From: Planning
Sent: 26 January 2022 10:24
To: Planning
Subject: REDACT AND UPLOAD 3/2021/1286 Ribblesdale ave
Attachments: IMG_5755.jpg

Subject: 3/2021/1286 Ribblesdale ave

PROPOSED SOUTH EAST ELEVATION
Scale 1:100

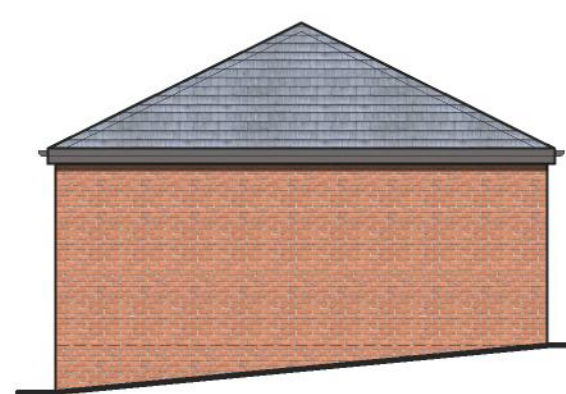
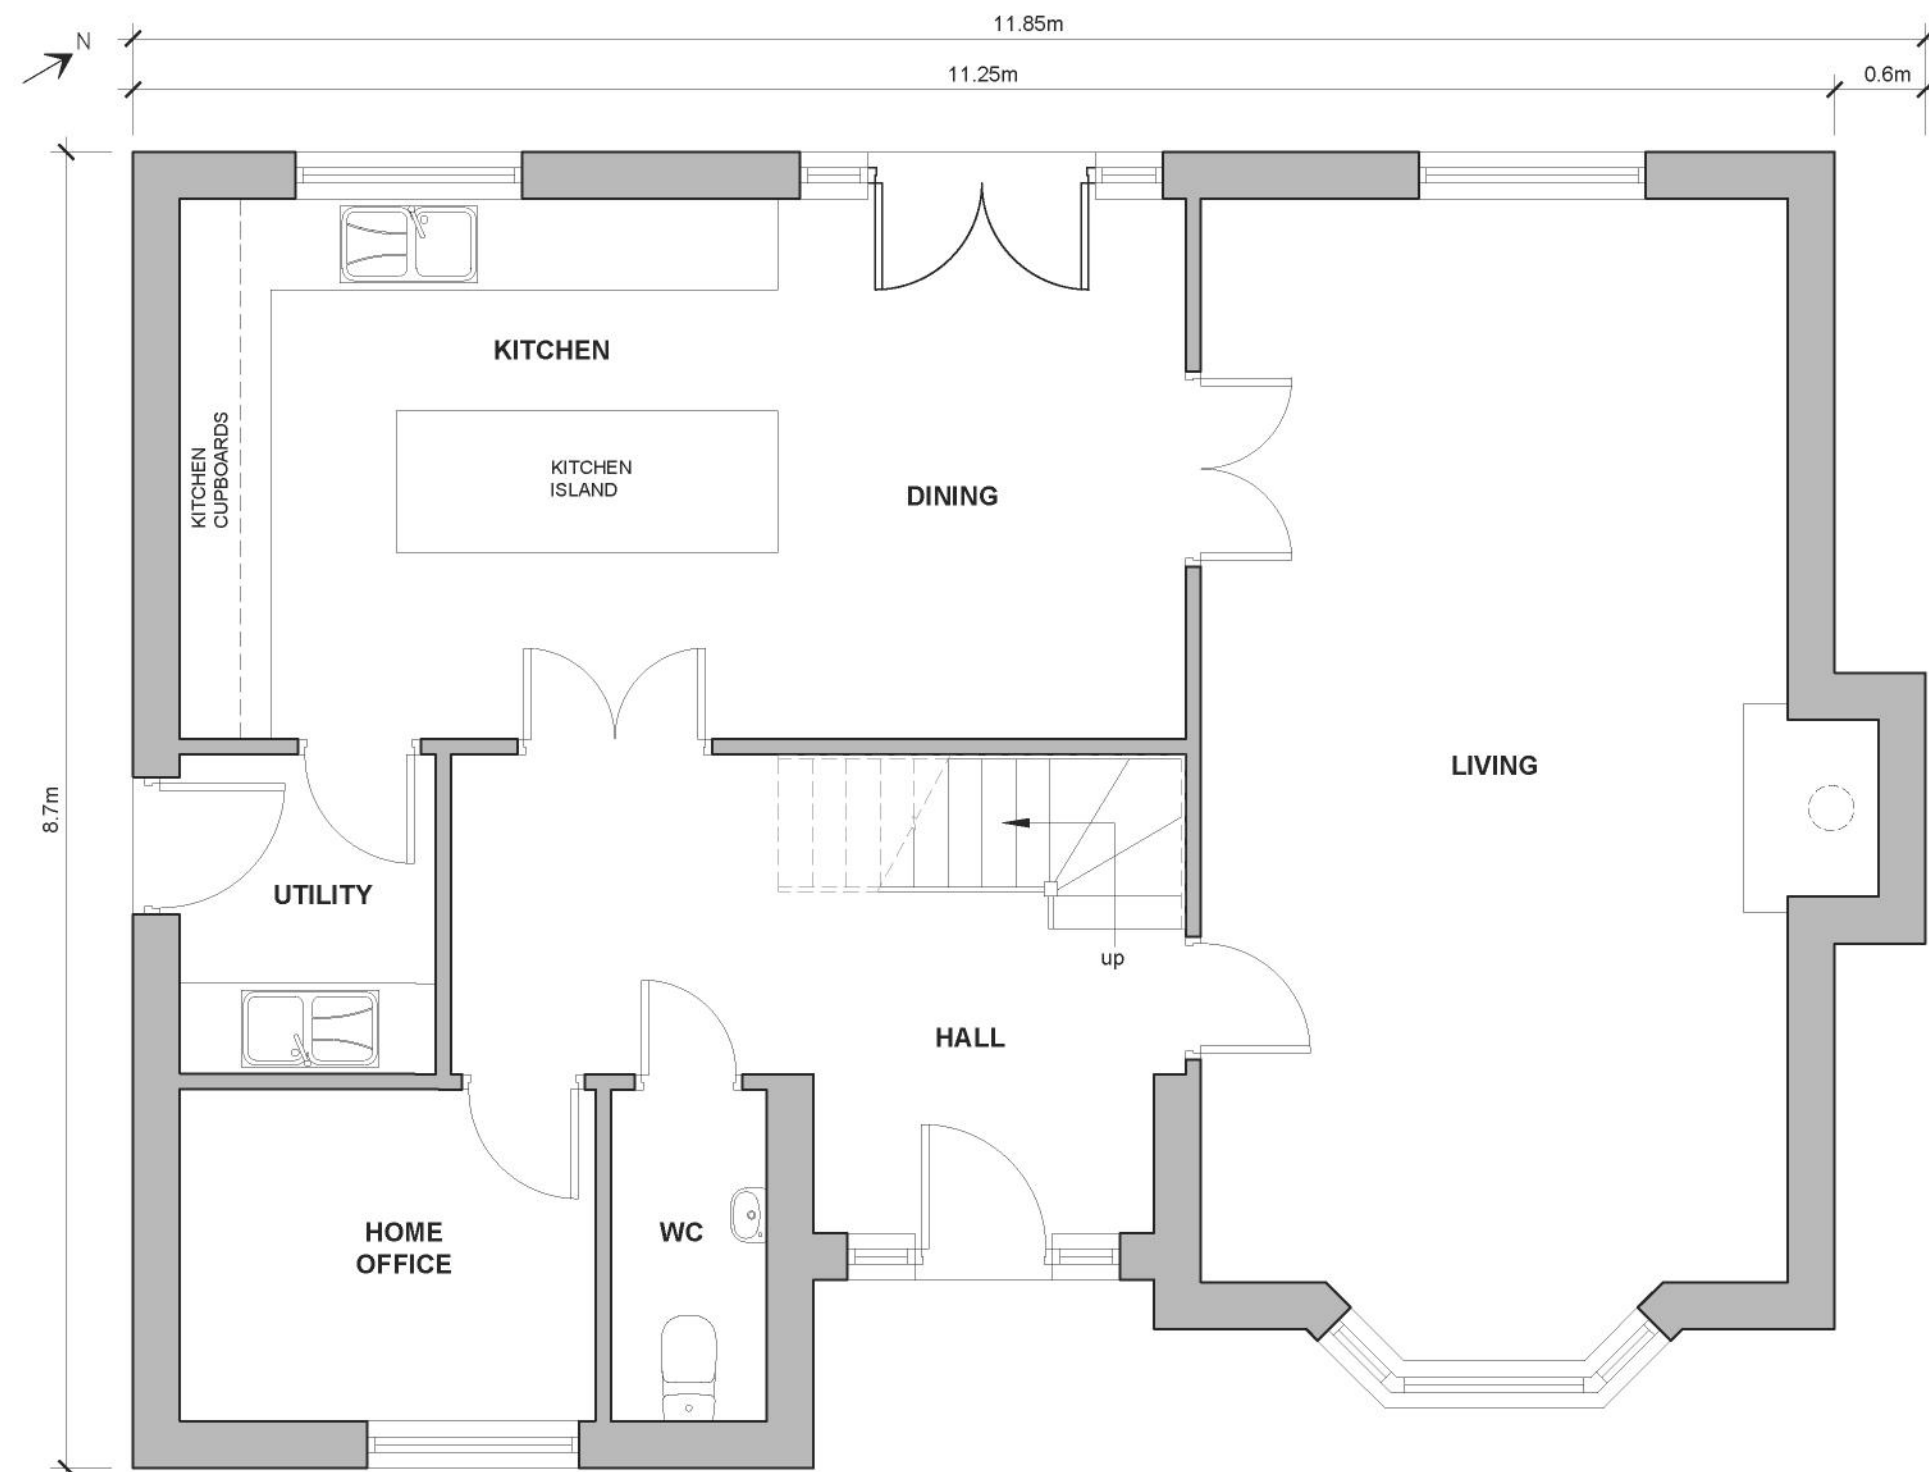
The new build should have a slate roof, stone window jarms and sills, it should be partly rendered, a red brick garden wall and all the trees and shrubbery that was chopped down replaced.

PROPOSED SITE SECTION A-A

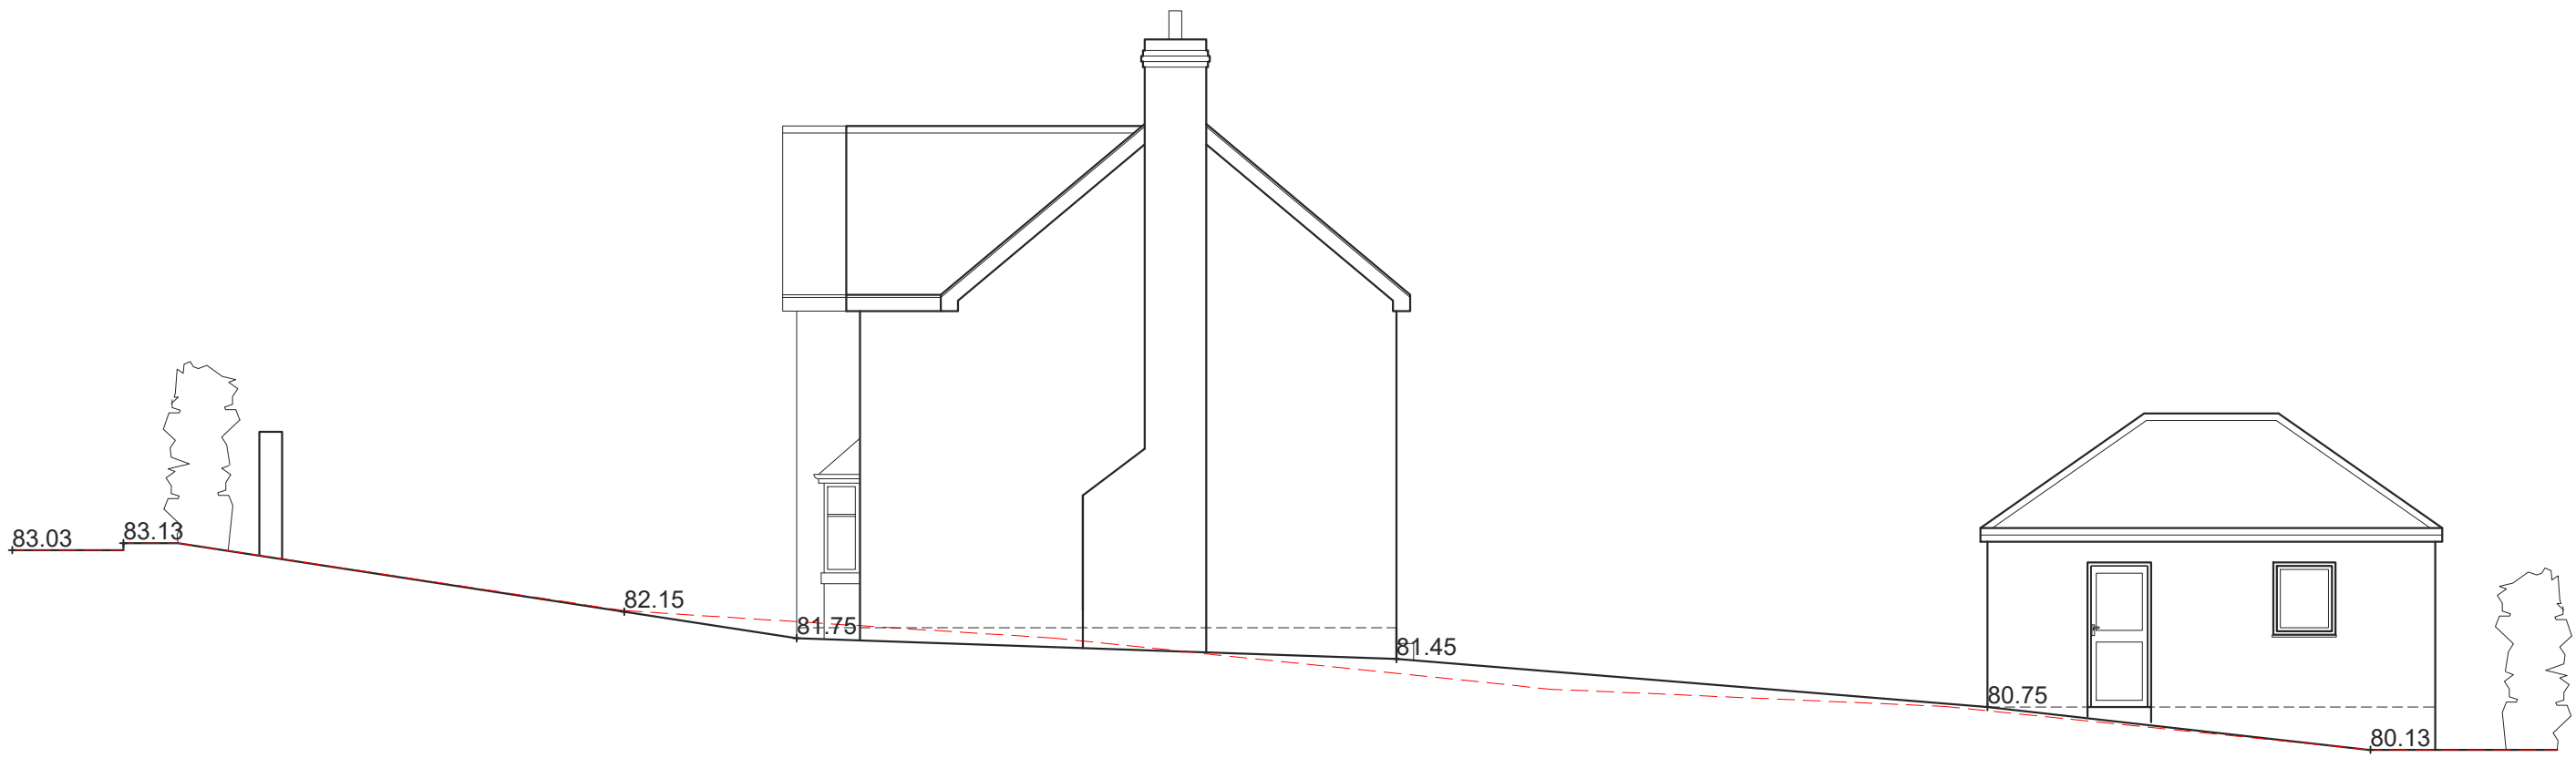
The front of the new build should be set back from Ribblesdale Ave, to line up with the front of next doors house not inline with the garage, otherwise the top of the house will be a lot higher than next door as the site slopes down Knuck Knowles Drive.
